CITY OF ALBUQUERQUE

Re: Cura Botanicals LLC Grow Facility
5904 Florence Ave. NE
30-Day Temporary Certificate of Occupancy
Transportation Development Final Inspection
Engineer's Stamp dated 06-14-24 (B18-D030)
Certification dated 09-26-24

Based upon the information provided in your submittal received 09-26-24, Transportation Development has no objection to a 30-day Temporary Certificate of Occupancy based. This letter serves as a "green tag" from Transportation Development for a 30-day Temporary Certificate of Occupancy to be issued by the Building and Safety Division.

ENLARGED SITE PLAN

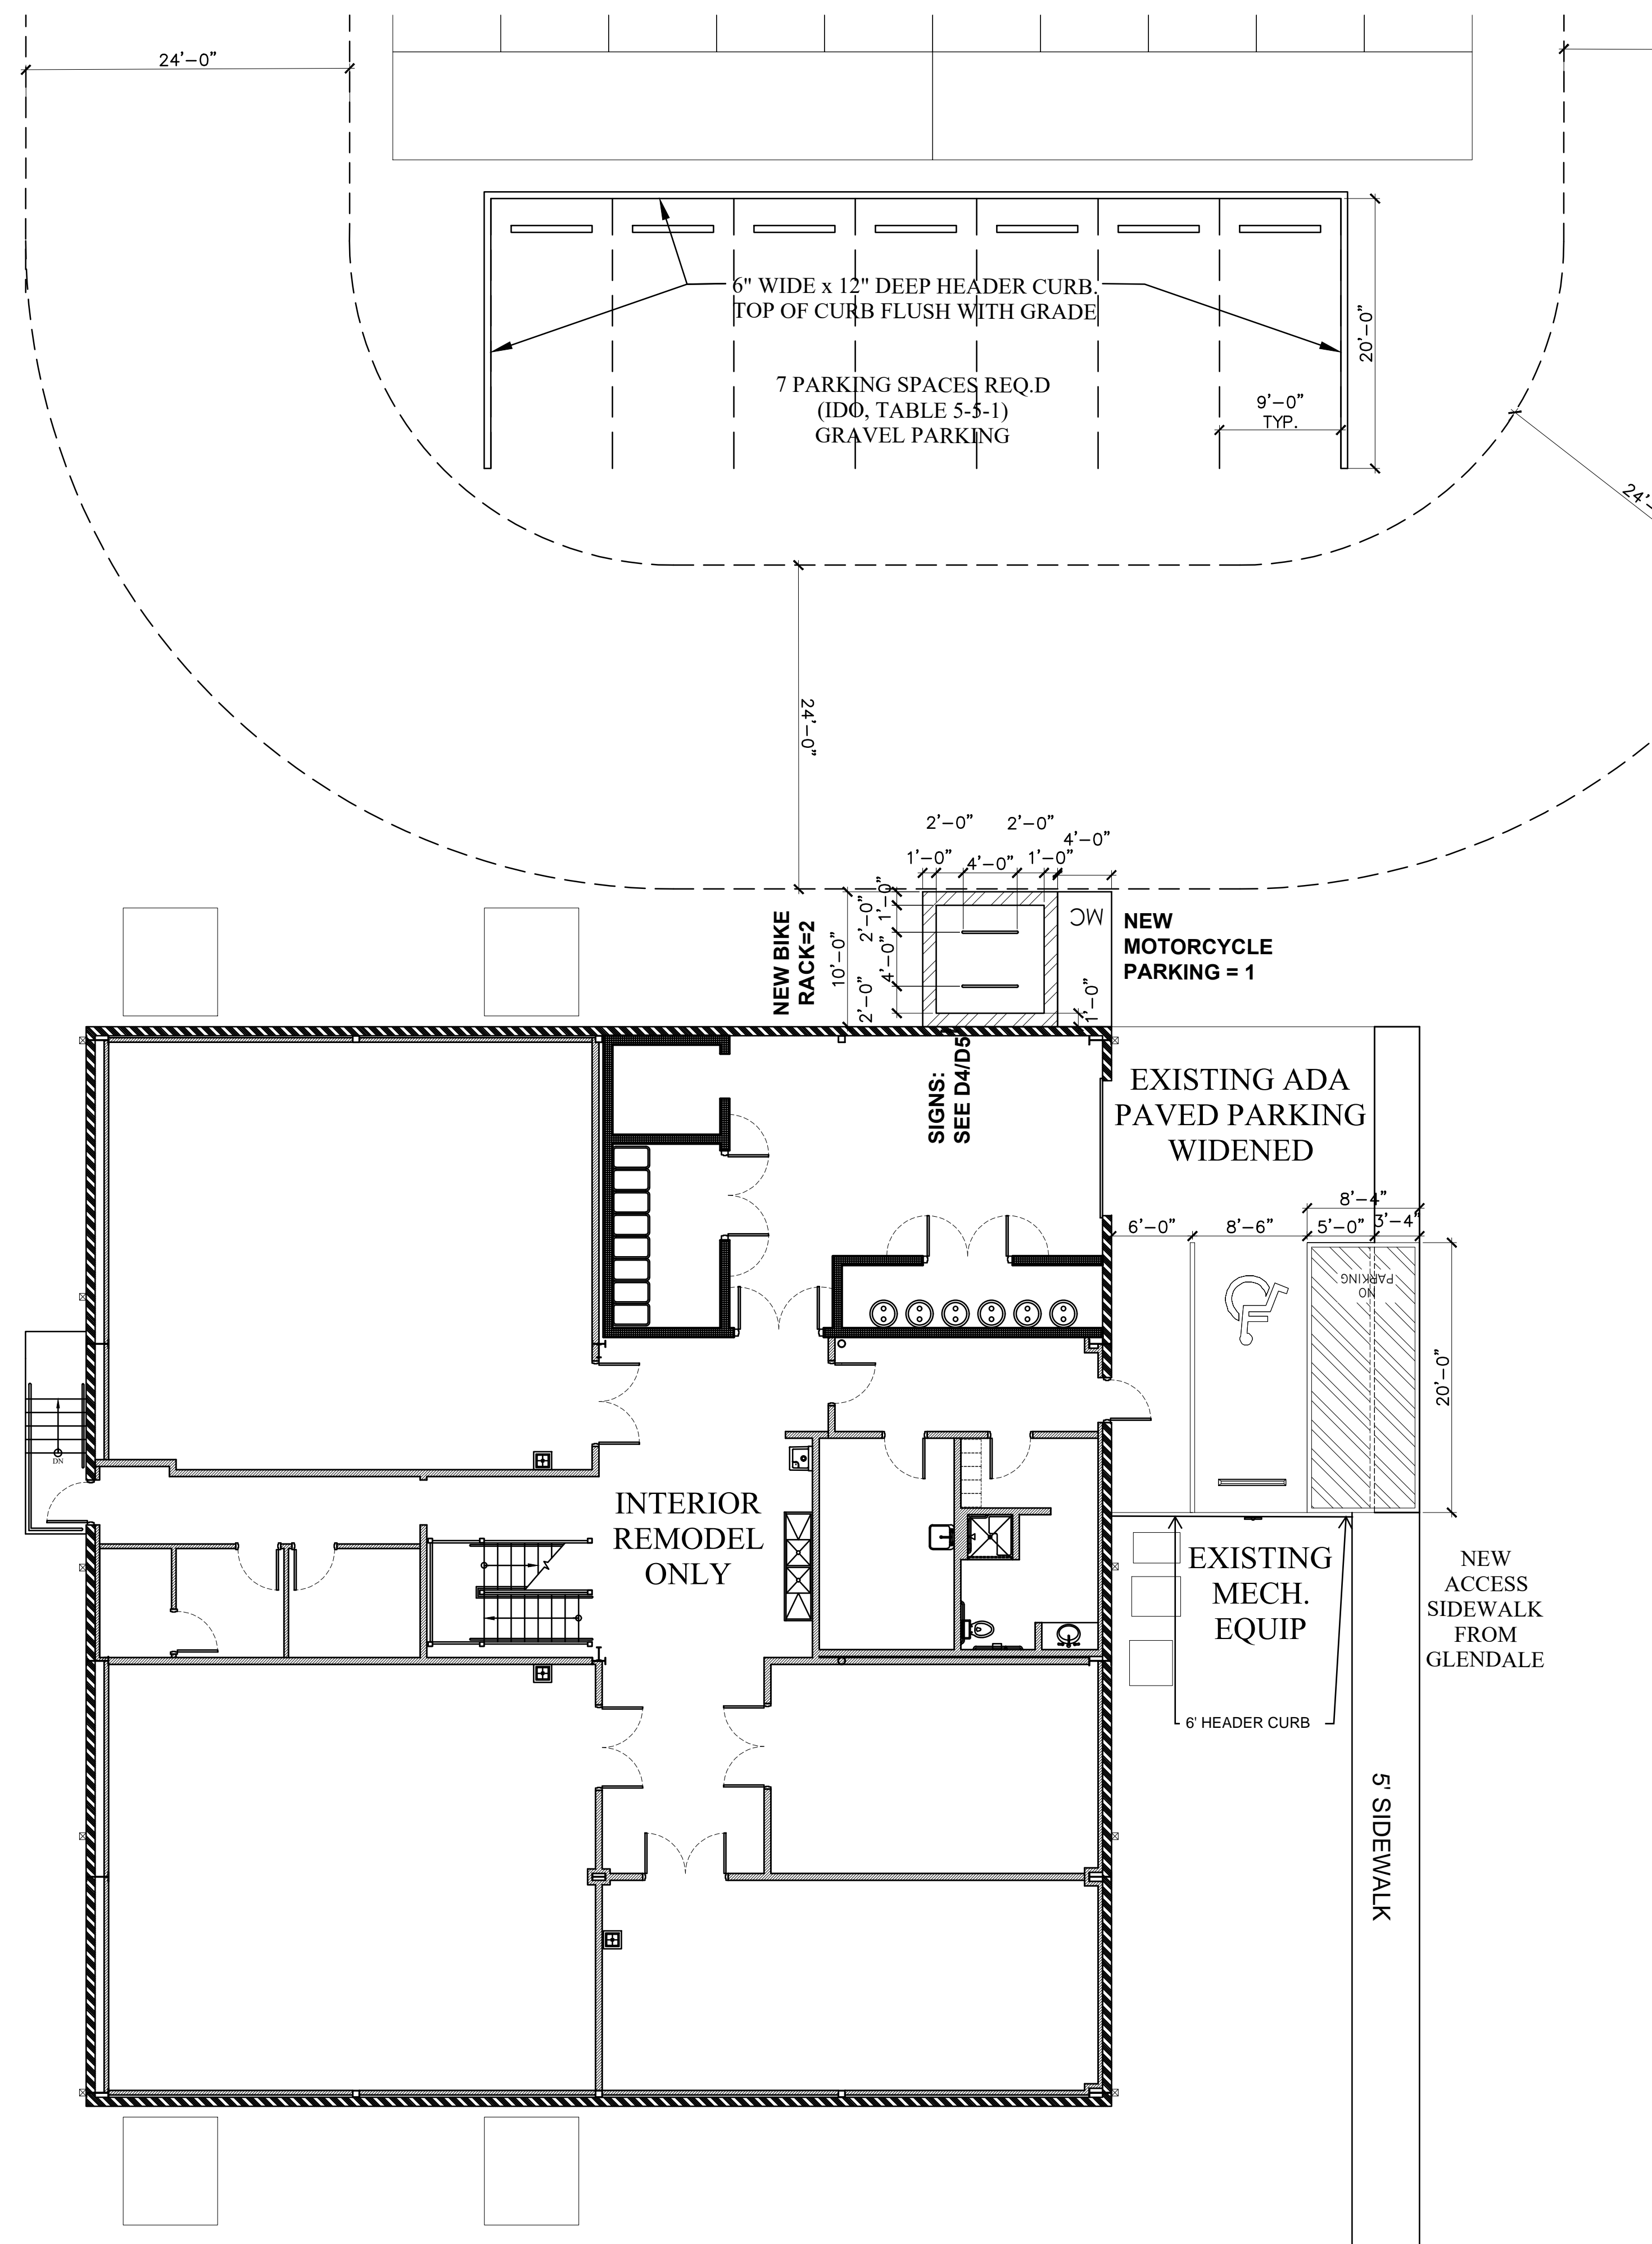
- The ADA access aisles shall have the words **"NO PARKING"** in capital letters, each of which shall be at least one foot high and at least two inches wide, placed at the rear of the parking space so as to be close to where an adjacent vehicle's rear tire would be placed. (66-1-4.1.B NMSA 1978)
